**RE: Review Comment Responses / Banning Lewis Ranch Village C
Colorado Springs, Colorado**

The purpose of this letter is to respond to CDOT Staff review comments (1st Review). We have provided detailed responses to the review comments and made revisions to the Traffic Impact Study as applicable. We remain available to discuss further if needed. The following is a summary of comment responses:

**PROJECT INFORMATION**

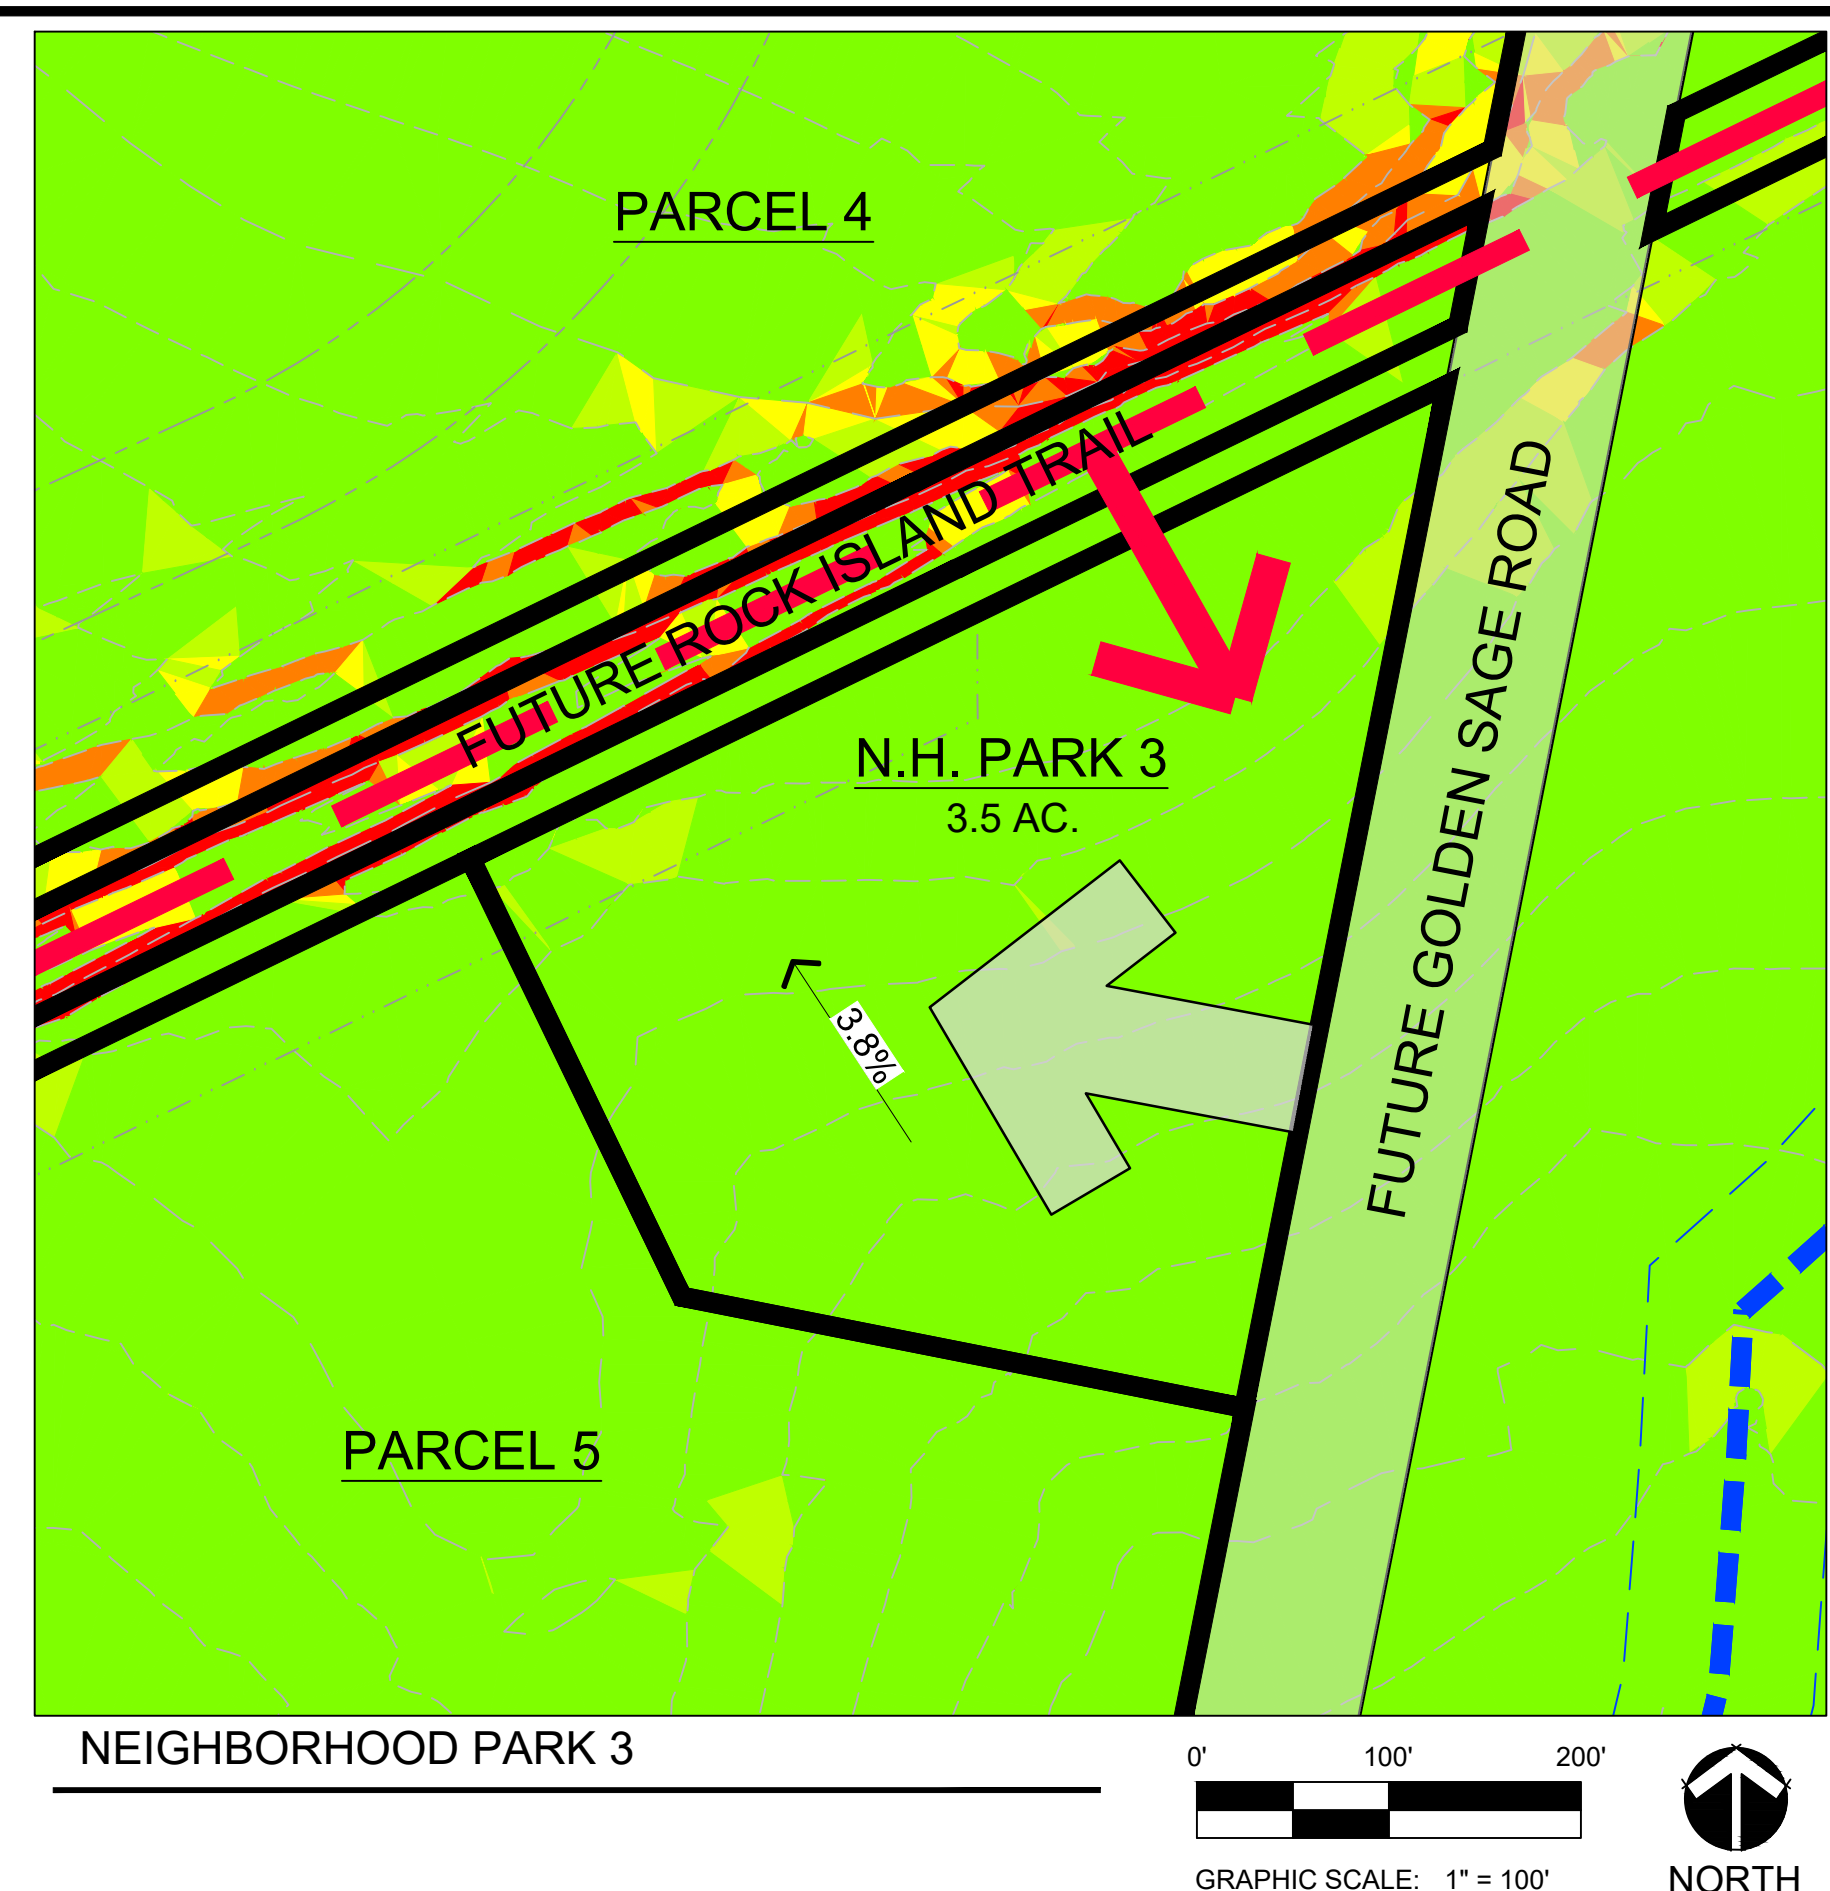
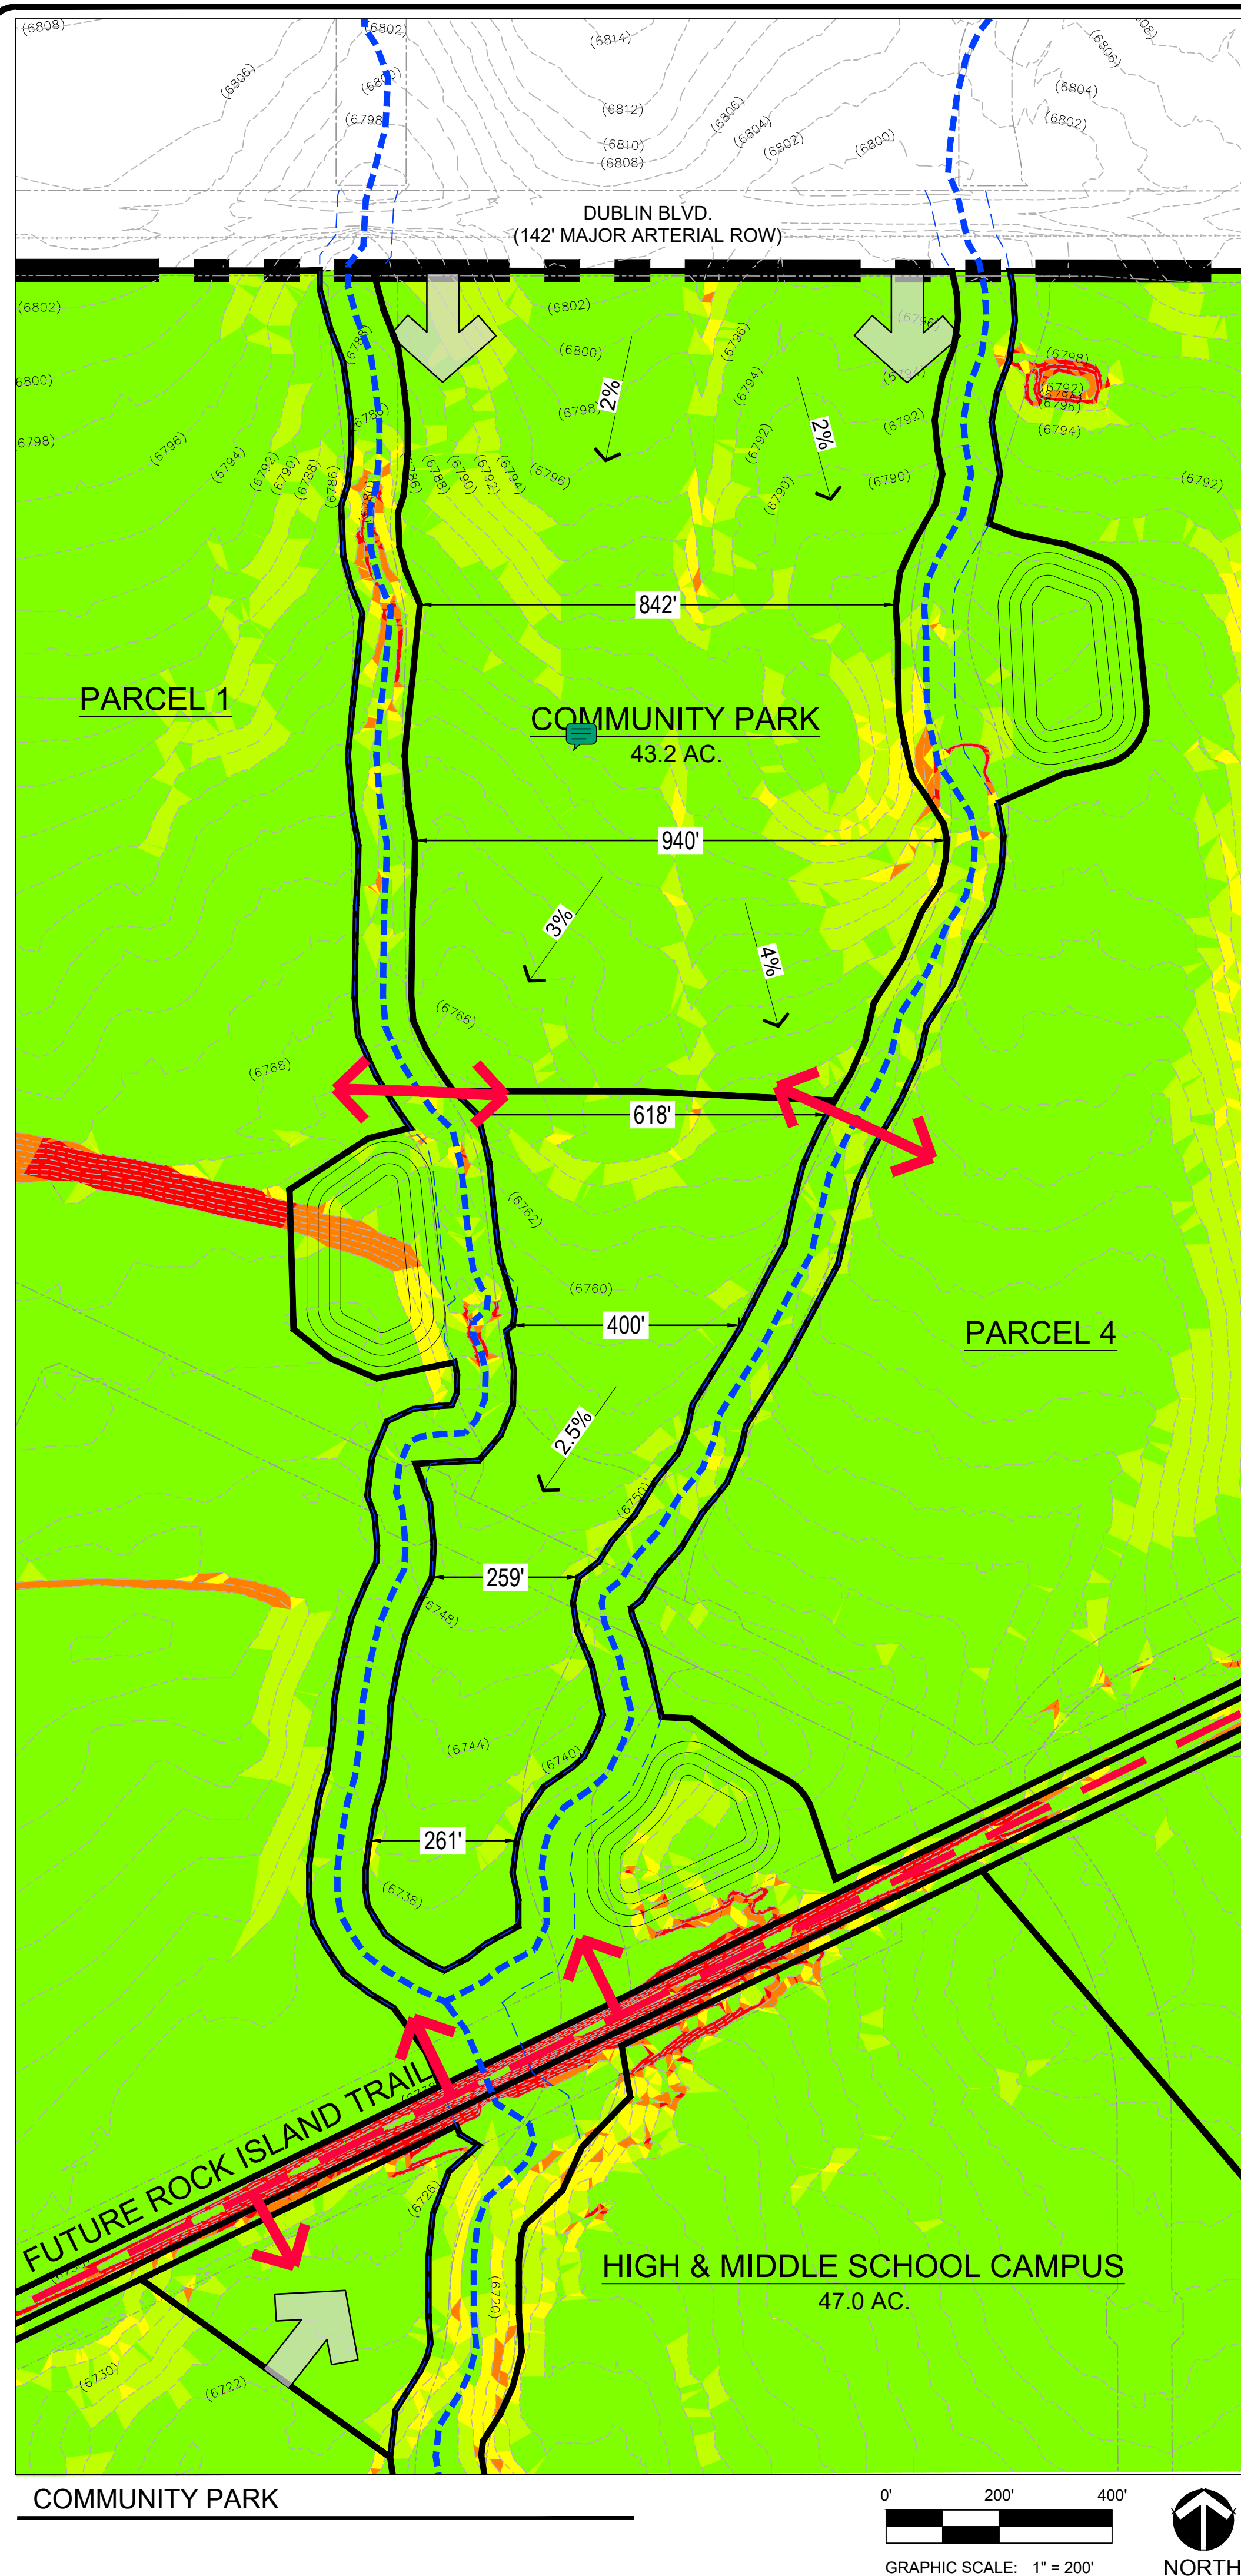
CDOT Staff Comment 4: Eliminate #11 access to US-24 and instead connect Dublin Blvd. to Falcon Hwy

Comment Response: Access Removed.

Figure 1: Traffic Analysis Study Limits

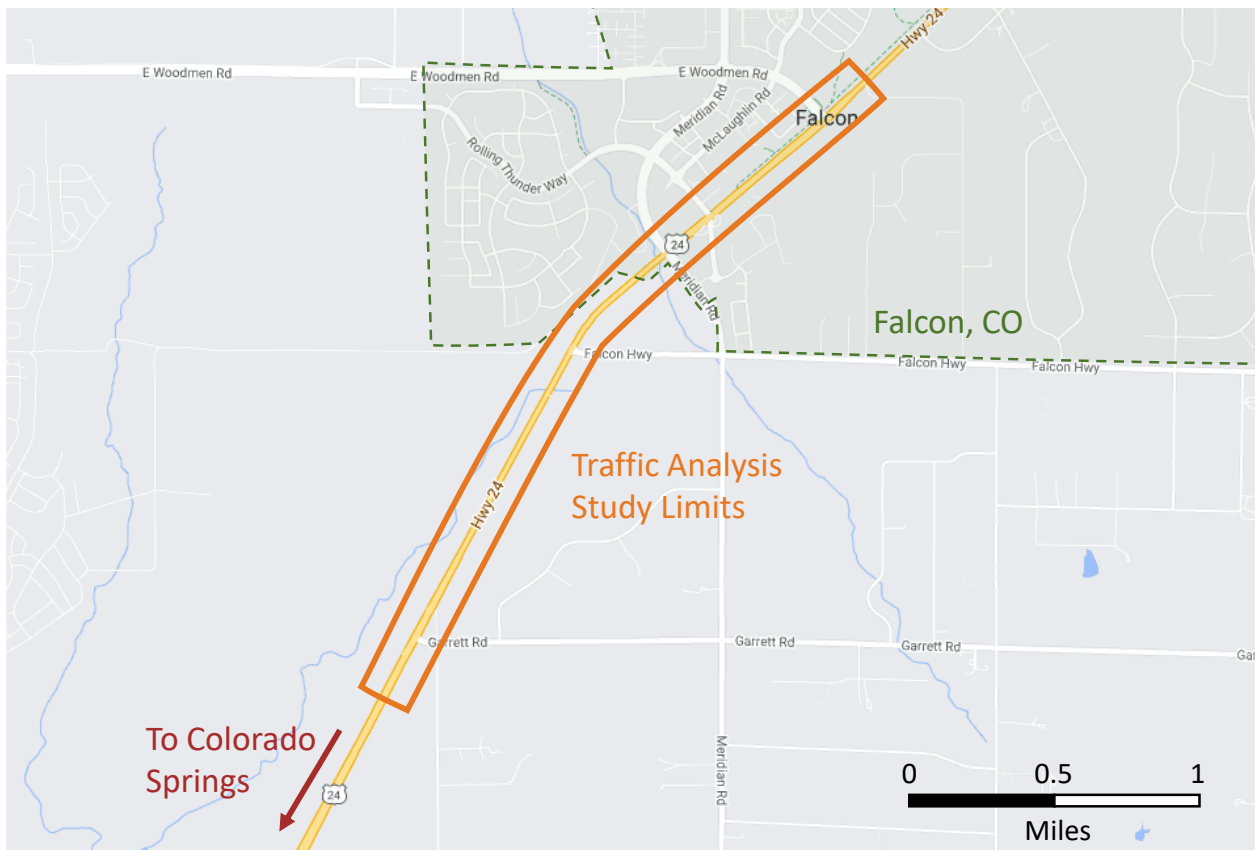
CDOT Staff Comment 1: US-24 South of Garrett assumed to have 6 lanes. Do not make this assumption in the analysis. Attached is the latest study at US-24.

CDOT Staff Comment 3: Study area: the network will need to be extended to include at least (all study intersections needs to be connected):

- a. US-24 & E Woodmen Rd
- b. US-24 & Meridian Rd
- c. US-24 & Falcon Hwy
- d. US-24 & Constitution Ave
- e. US-24 & Marksheffel Rd
- f. US-21 & Stetson Hills Blvd/Garrett Rd
- g. US-21 & Dublin Blvd
- h. US-21 & E Woodmen Rd
- i. If the development adds 5% or more traffic compared to the available capacity- include those intersections too

Comment Response: Analysis updated to analyze U.S. Highway 24 as a four-lane cross-section in the long-term year.

Comment Response: Intersections A-E have been added to this analysis as requested. It is acknowledged that CDOT Region 2 utilizes the SHAC guideline of 5% contribution when determining what intersections to include in traffic analysis. However, in coordination with CDOT Staff via email dated 2/12/2025, Staff was in support of excluding intersections, F, G, and H from this analysis given that the development would not be requested to assess or provide any improvements to these intersections.
